We strongly object to planning application 3/2022/0467 36 Painter Wood as the proposed new development has done little to address our concerns and objections on the Refused planning application ref: 3/2021/1122.

PROPOSED SITE PLAN

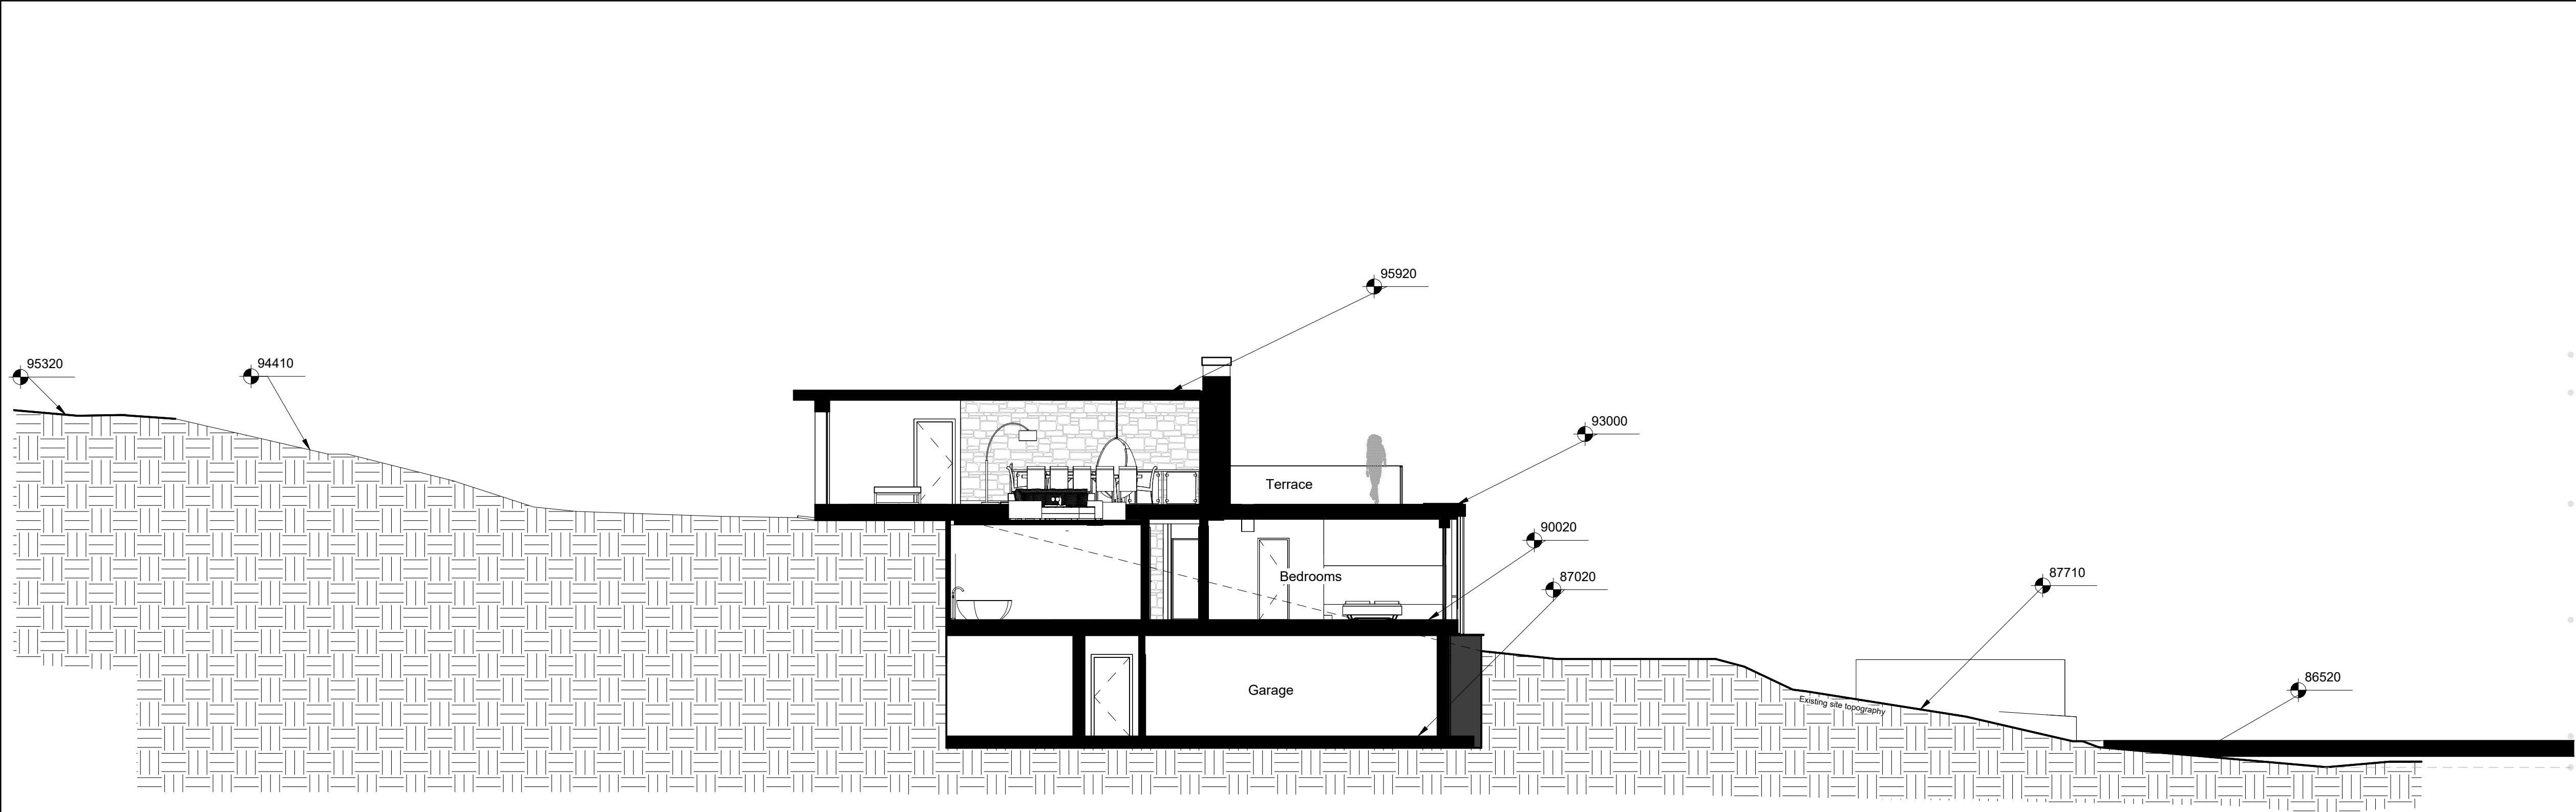
3. The properties along Painter Wood follow a clear build line, which can be seen on the below site plan shown in red. When

6. The boundary on the proposed site plan is incorrect according to

As a result they appear to have deviated from this line, annexing a large mature tree which grows directly and removing this as part of the proposed development.

Proposed North East Elevation

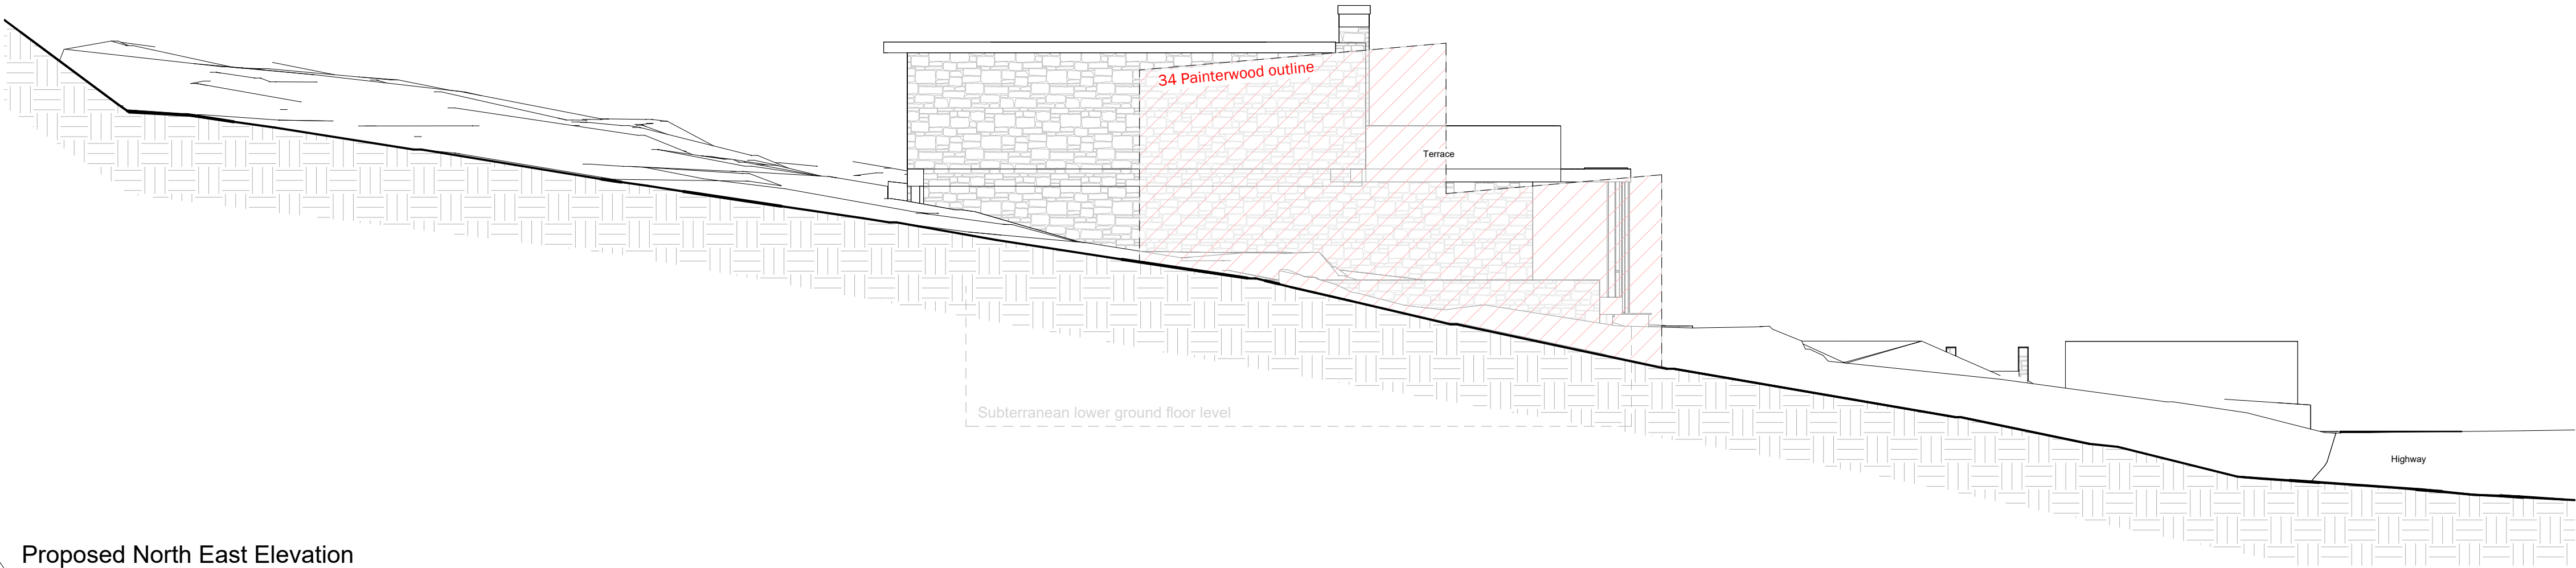
4. The proposed development includes a 'monolithic' wall to the north east elevation which

The impact will be

Natural light
